CITY OF ALBUQUERQUE

April 14, 2017

Re: Hotel Chaco
2000 Bellamah Ave NW
Request 60-Day Temporary C.O. – Accepted
Engineer's Stamp dated: 7/31/2015 (H20D033)
Certification dated: 1-18-17

©2014 Gensler

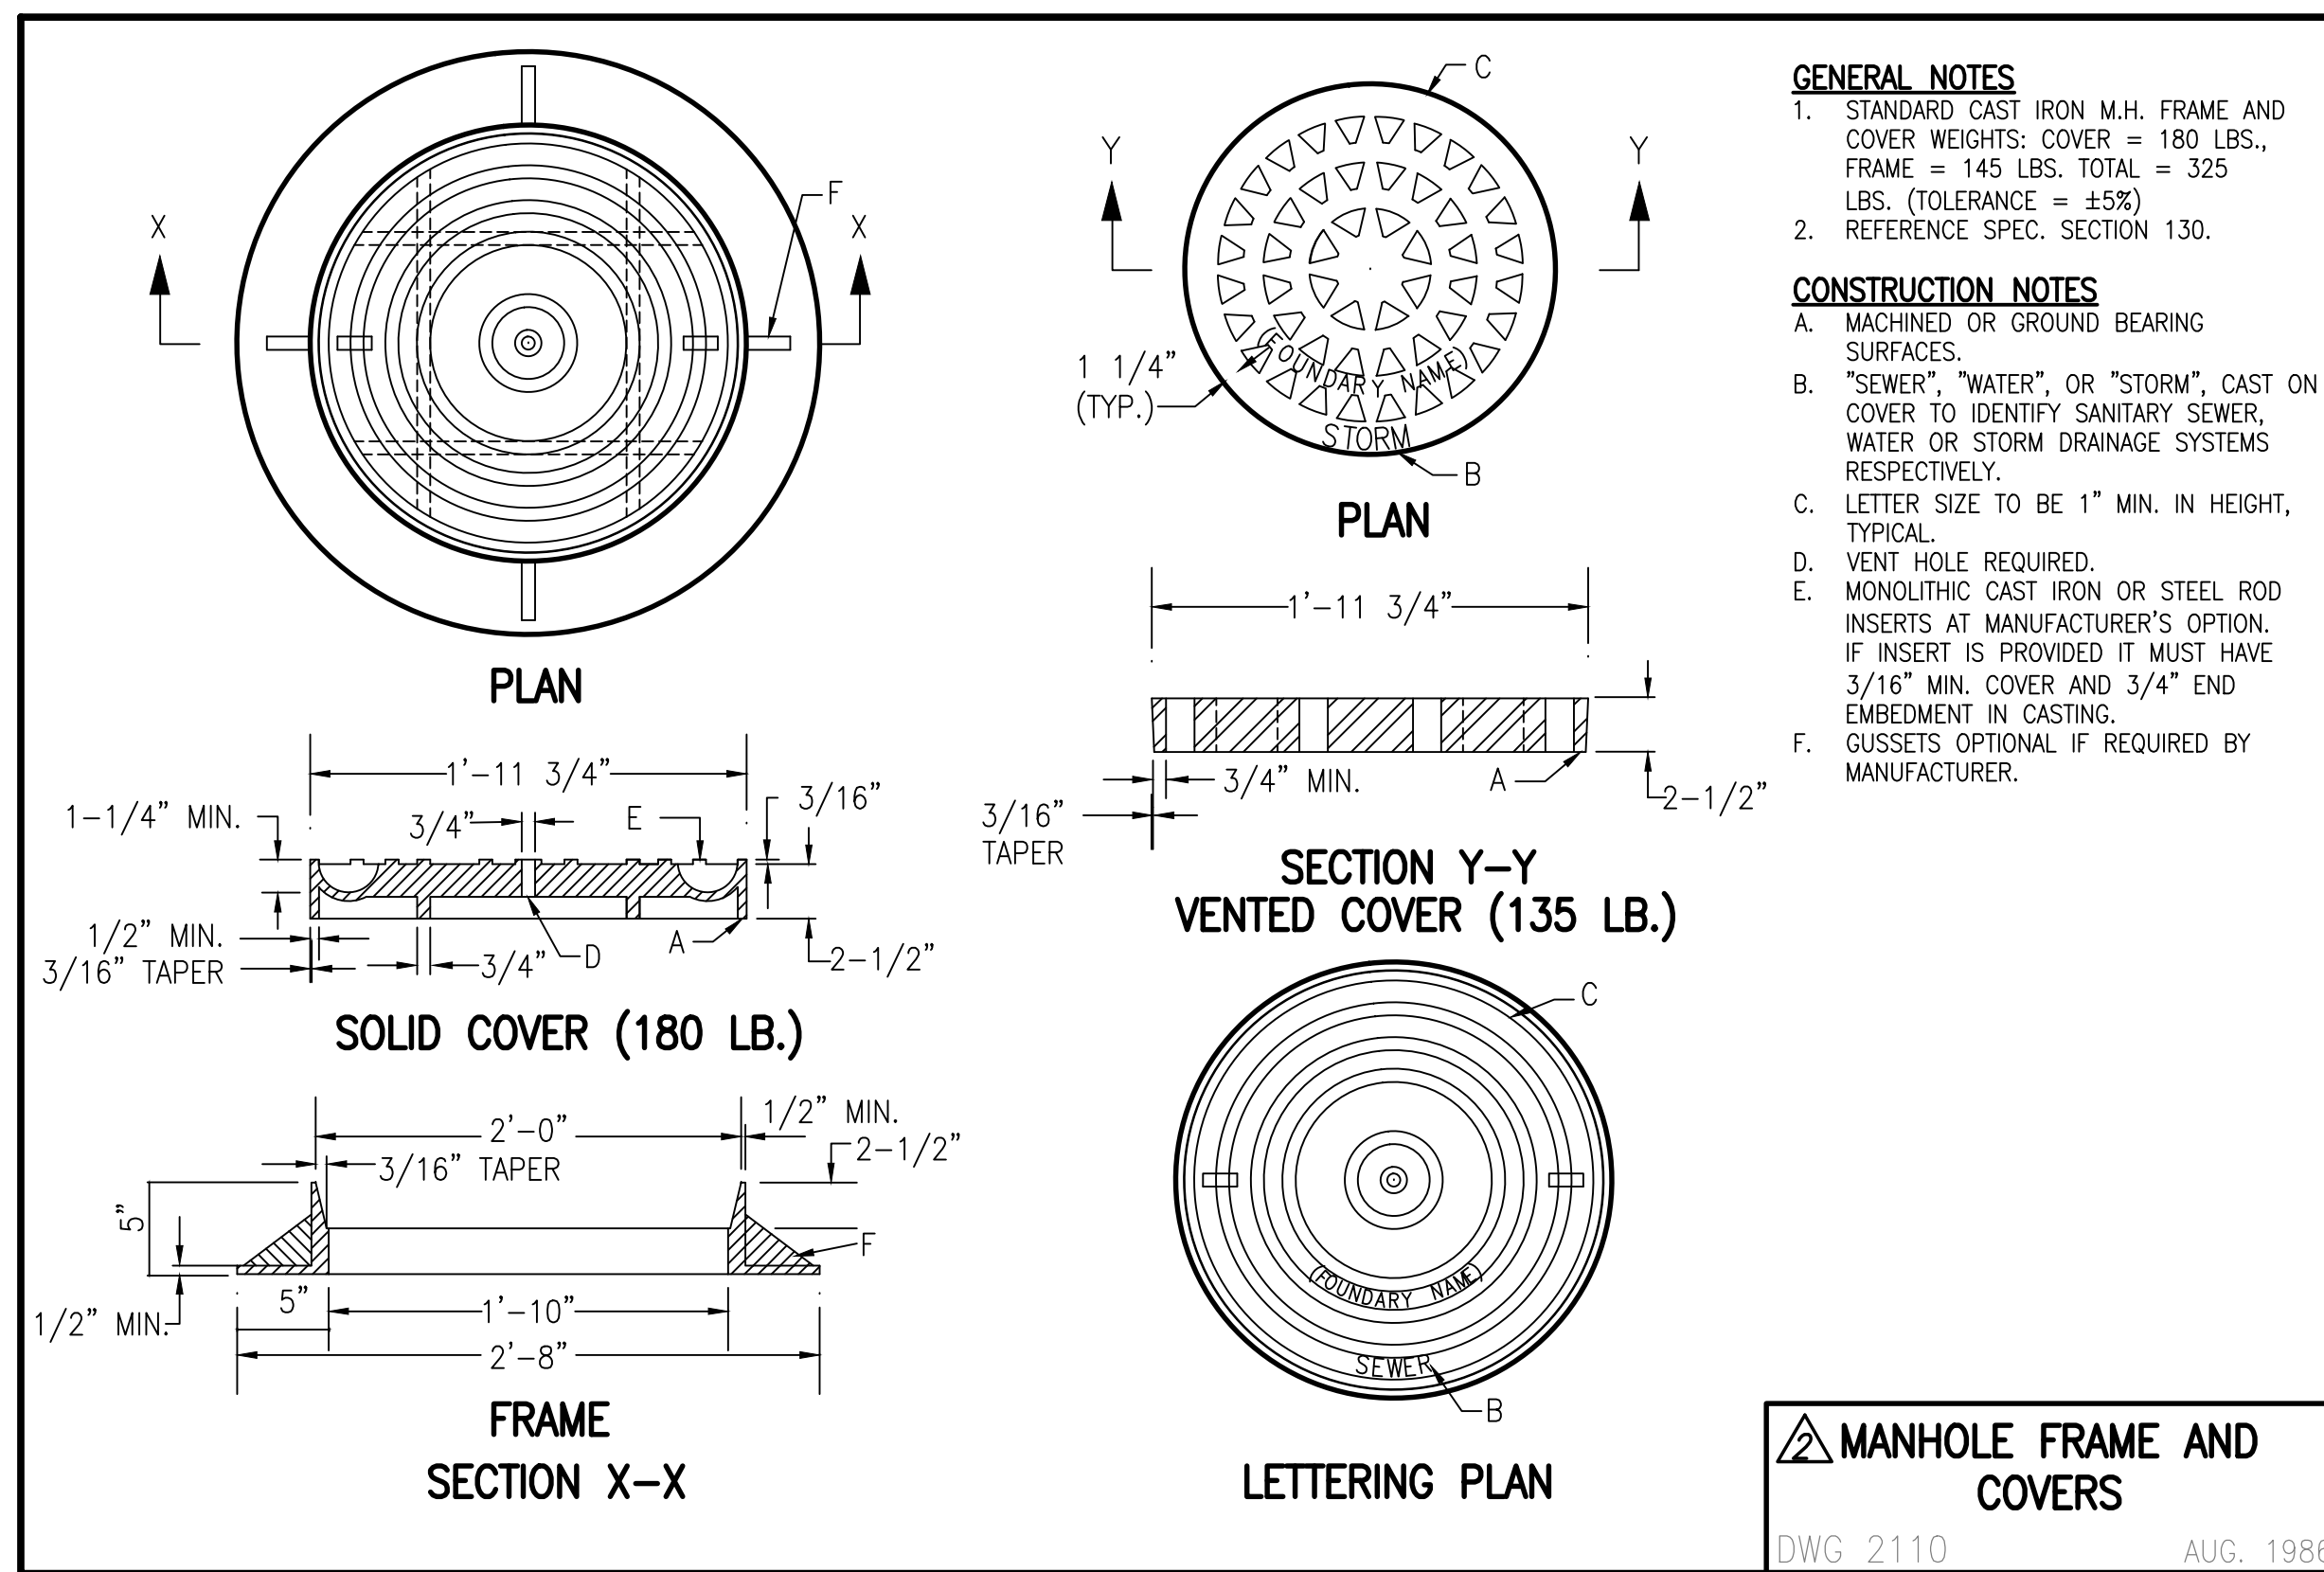
- The sidewalk culvert on Bellamah is incomplete. Must be extended 1' west of sidewalk and east side must be extended to street.
- Note #6 inlet appears to be in mechanical courtyard and not at NW corner of building. Clarify inlet location on drawing.
- Note #13 water harvesting area is incomplete.
- Roof drain at SW corner of building is not on drawing.
